# Charlotte Department of Transportation

## Memorandum

**Date:** May 30, 2008

**Subject:** Rezoning Petition 08-070: Located in the block bounded by North Davidson Street, East 26th Street, East 27th Street & Yadkin Avenue (revised 5/23/08)

DATE: January 3, 2008  
 DESIGNED BY: CCM  
 DRAWN BY: SK  
 CHECKED BY: CCM  
 SCALE: 1" = 40'  
 PROJECT #: 1007324  
 SHEET #:  
**RZ-1.0**

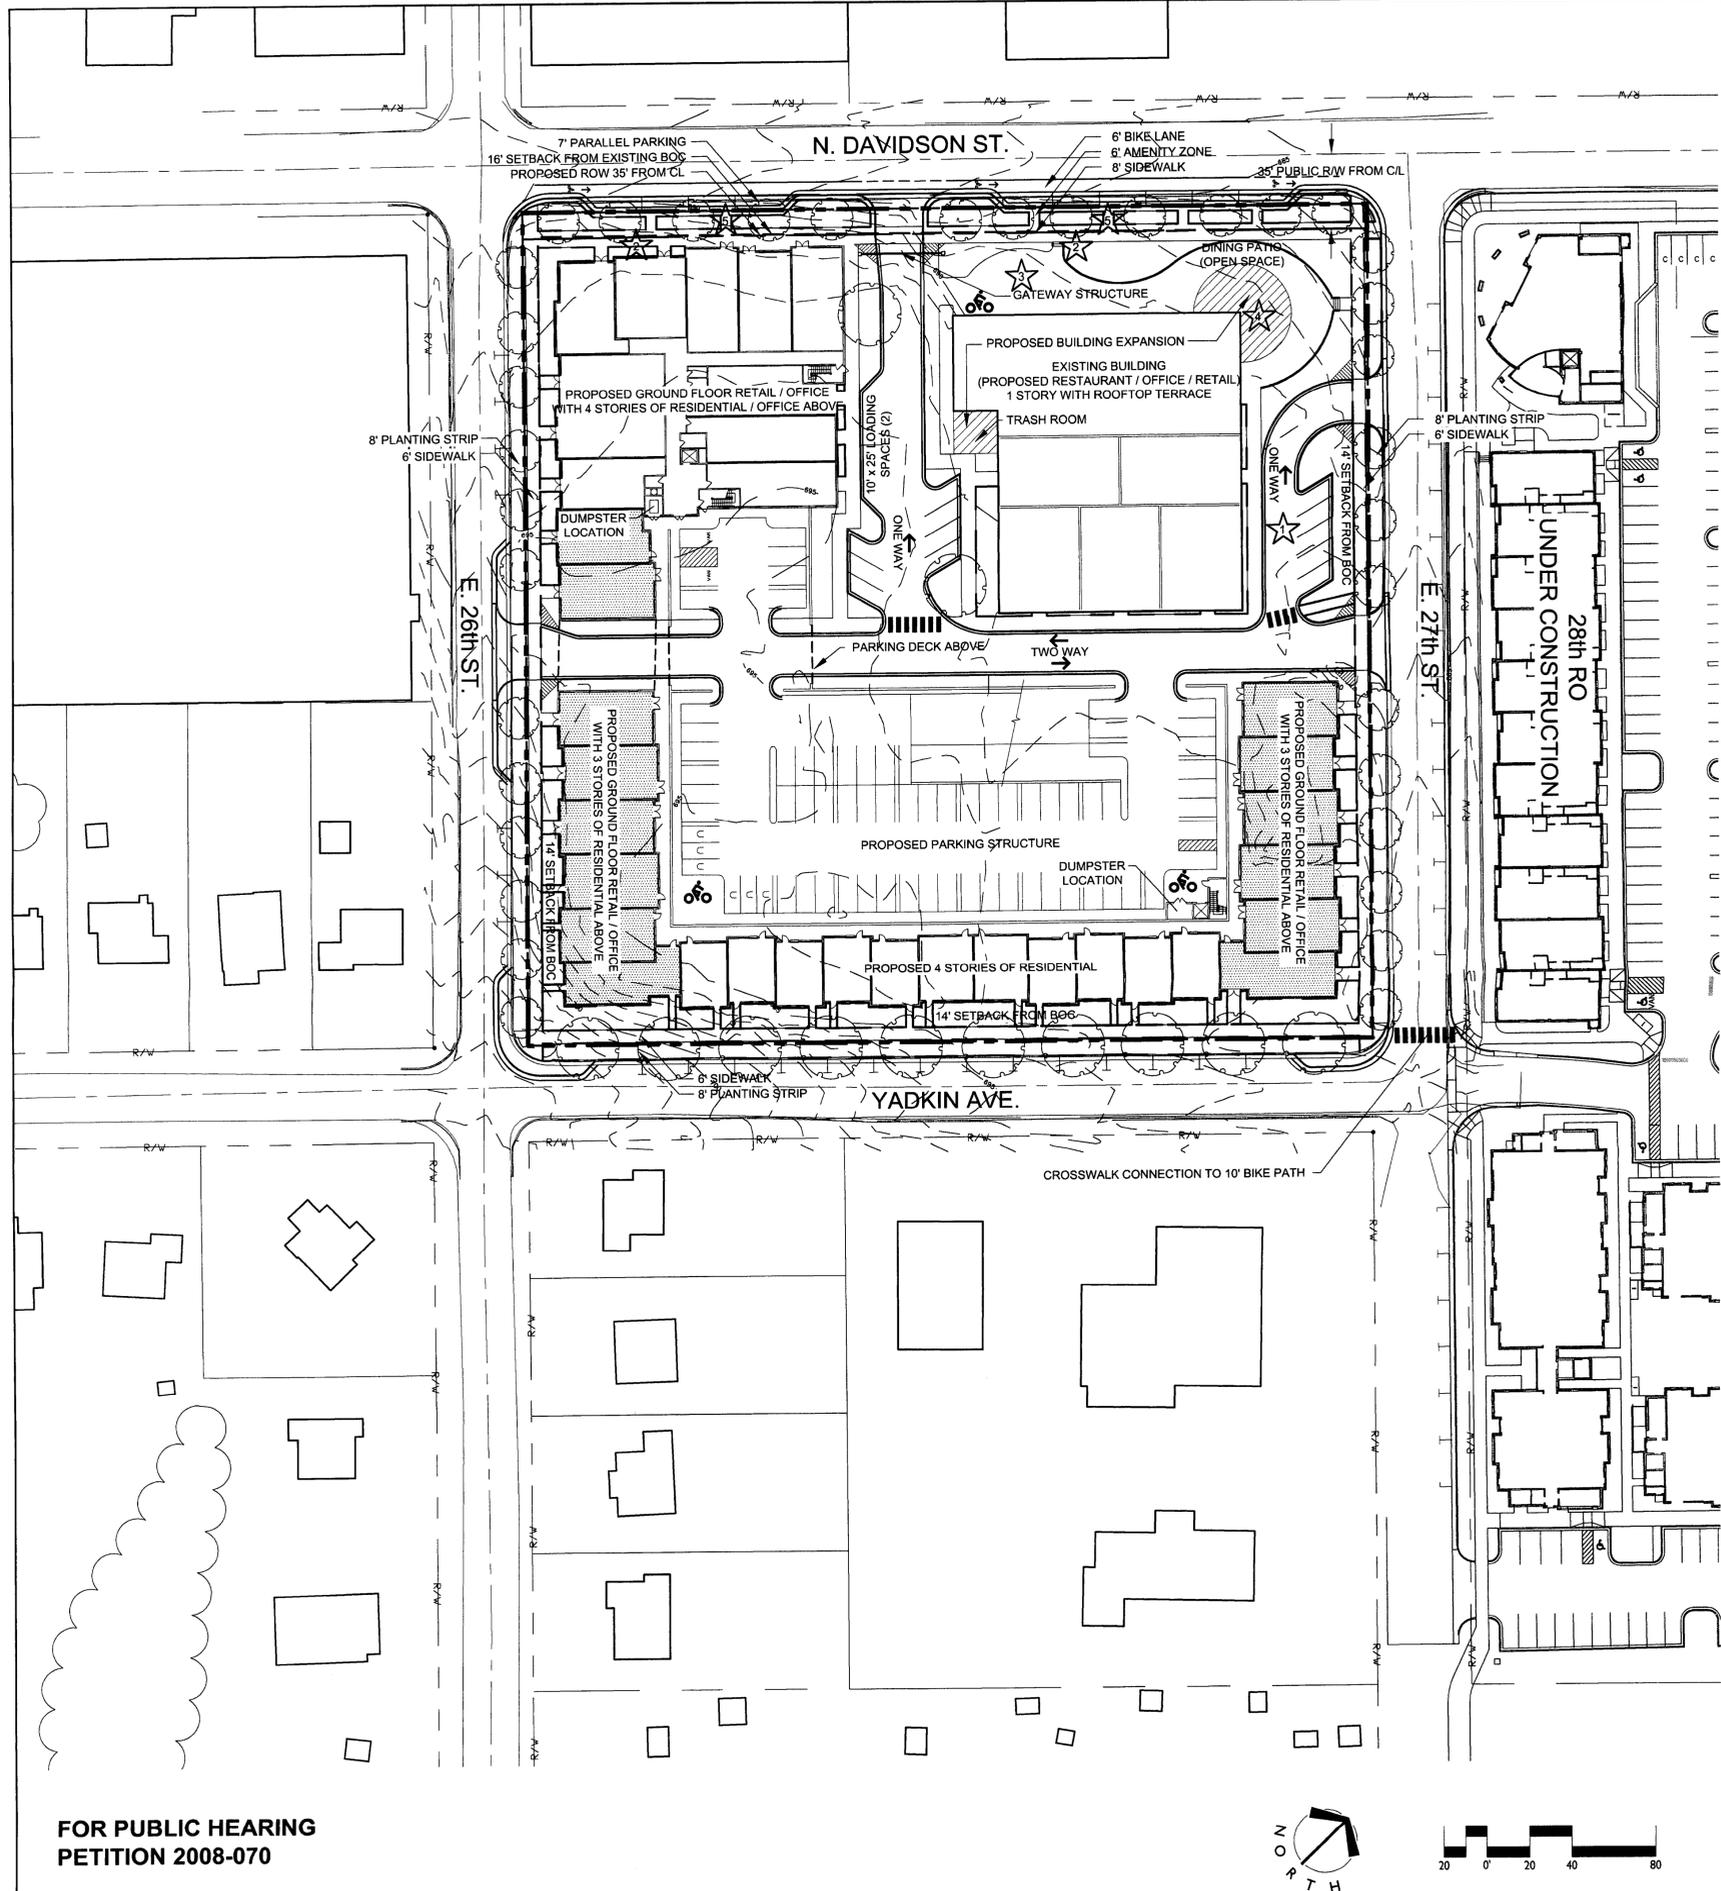
1. The petitioner/developer has generally shown street cross sections that meet the *Urban Street Design Guidelines*. Adjustments to the new curblines as shown will be necessary and we will meet with the petitioner to further discuss and resolve.

1. The planned North Davidson bicycle/pedestrian connection to Pickney needs to be included in this plan. (*Previous comment*)
